Planning Correspondence "Request for Further Changes"

From: Simon Davis
Sent: 21 March 2025 15:58
To: 'Helen Murch'
Cc: Luke Vallins [REDACTED] Peter Cleveland [REDACTED]
Subject: P/114/24/RES

Further to our chat earlier, I consider the remaining interface related issues to be:

Project Land West of Pagham Road
Drawing House Type 4.1 - 2 Block Elevations

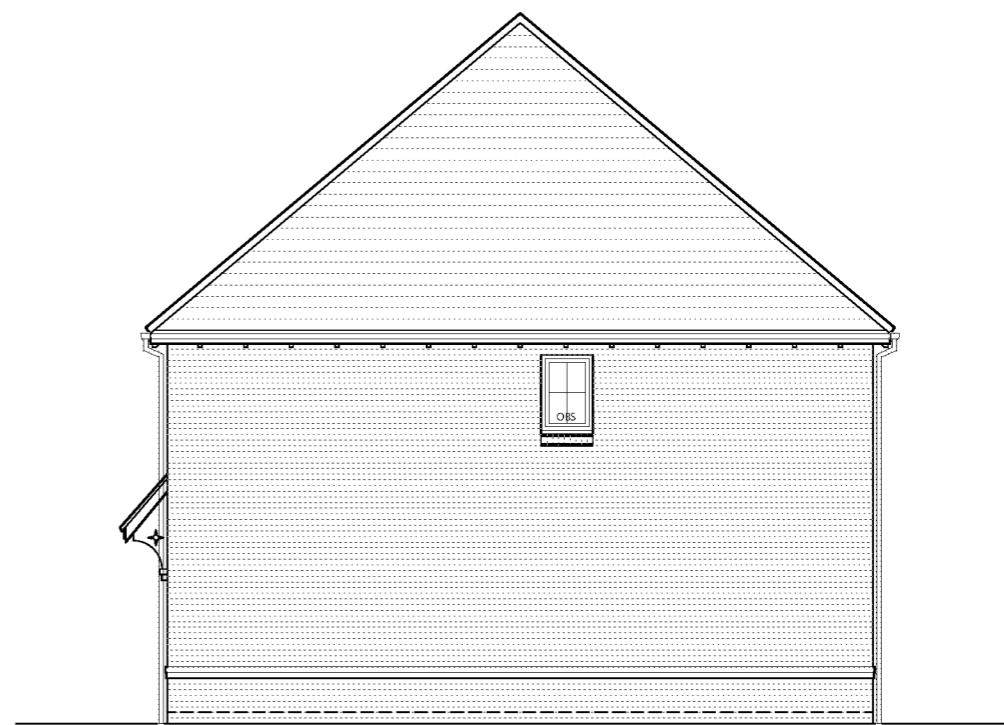
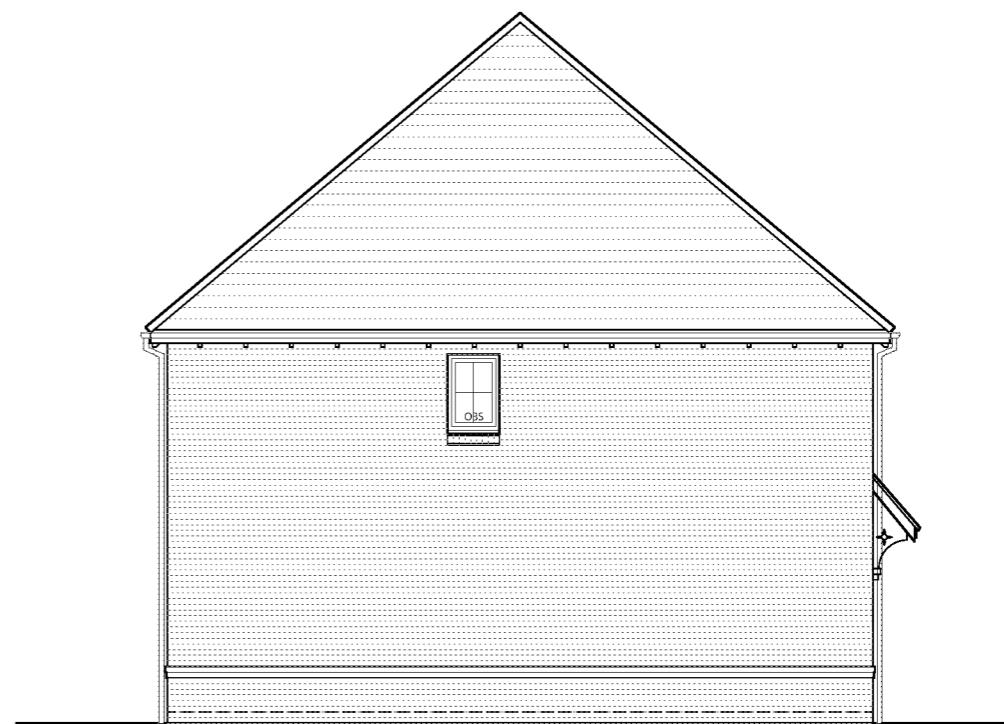
- Rear of plots 14/15 (2 x FF bed windows) to rear of 8 Mill View Close is 16-17.2m (14.5m to edge of conservatory) (21m requirement) – still an issue as bedrooms proposed in the first floor of 14/15 and the proposed planting (hedge and small trees) will take time to grow. In addition, 8 MVC is elevated (mobile homes tend to be around 0.6m higher than ground level). If you are able to provide a drawing that shows no line of sight from the FF windows to the roof of 8's conservatory, then this may resolve this to my satisfaction but if this is dependent on landscaping reaching a certain height first then our concern may remain.

Project	Land West of Pagham Road		
Drawing	House Type 2x1M - Option 3 Elevations		
Client	Bargate Homes		
Job no.	BARG230419	Date	January 2025
Dwg no.	HT.2x1M.e3	Rev.	B
Author	CJB	Checker	
Status	PLANNING	Scale	1:100 at A3
Client ref.		Office	Romsey

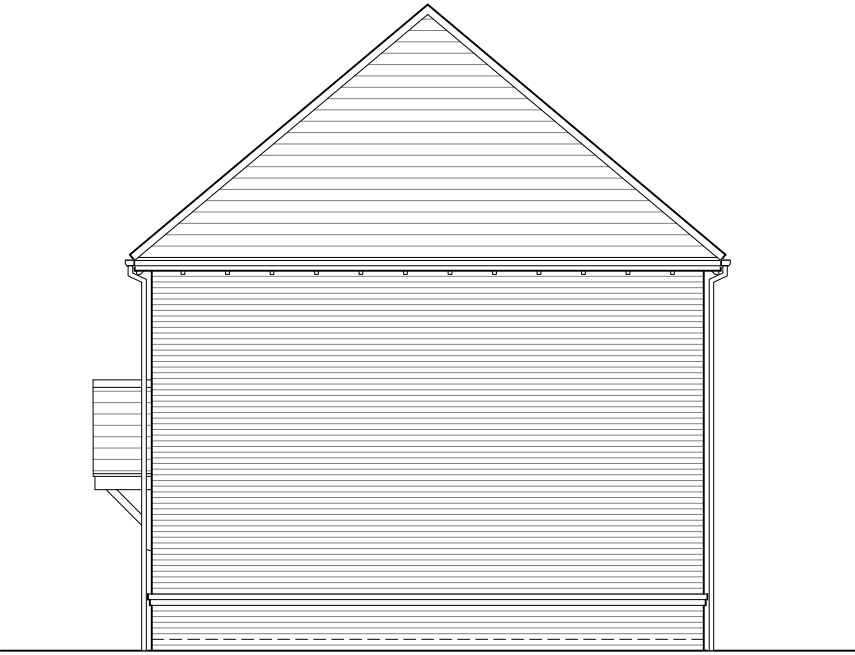
- Rear of plot 21 (FF 2x bed windows) to side of 37 (FF lounge window) is 12m (14.5m requirement). You now propose that both of the FF lounge/kitchen windows are o/g but this is not appropriate where there are no other windows to this space and future homeowners may decide to change the glazing.
